Scheme Reference: TRO10038
Unique Reference: 2002 8284

Comments on additional information/submissions received after Issue Specific Hearings

1. The Proposal

2.3 Omit Norwich Road junction in favour of a new junction further east and a new link road to Weston Road/Ringland Road

Option 2 Sketch. Sept 2021.
Ringland Road extended past Lower Easton.
September 2021

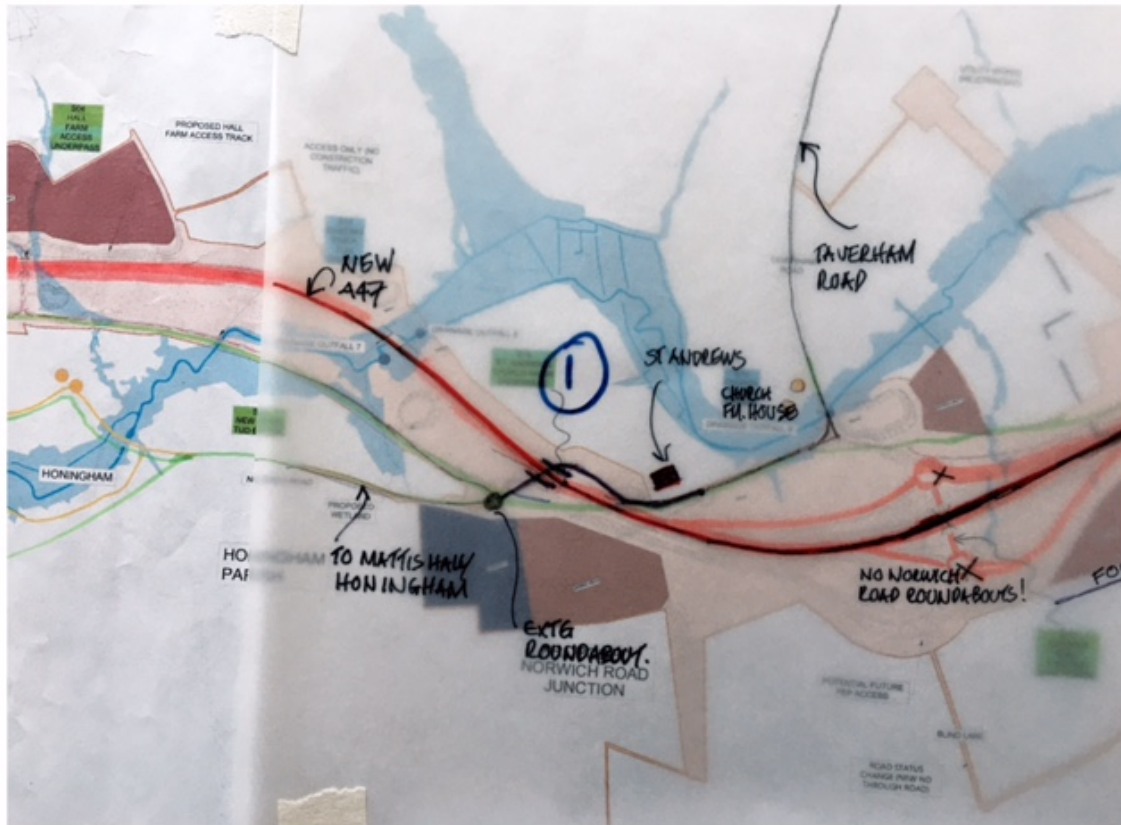
We are concerned that the proposal to vary the Norwich Road junction by relocating it as far east as is suggested has a massive detrimental impact on the estate which as mentioned before is already beset by this and other schemes; A47, NWL, Orsted and Equinor.

- i. The revised junction proposal is under the National Grid power lines, which means presumably they would need to be relocated.
- ii. The link road is approximately 1,100m long, so would be very expensive with a significant crossing required over the River Tud, taking yet more land, and interfering with an area otherwise destined to be only relatively marginally affected by the view of the works

- iii. Access to Lower Easton would only be possible from the north or from the direction of Easton village which precludes access for traffic from A47, without having to travel through either Easton or Honingham village, which doesn't seem very logical.

- v. The works compounds are not being acquired, only used temporarily so a significant amount of extra land would be required from the Easton Estate.
- vi. The road would cross directly towards a cluster of attractive dwellings and be in full view with dramatic consequences for the value and amenity for each of them.

- vii. The proposed link road would cross the River Tud and adjacent marshy grassland and woodland which the family would prefer to leave unaffected. The River Tud is a designated as County Wildlife Site.

- x. The works are in large part outside the development red line boundary so the DCO would have to be set aside and the scheme commence again.
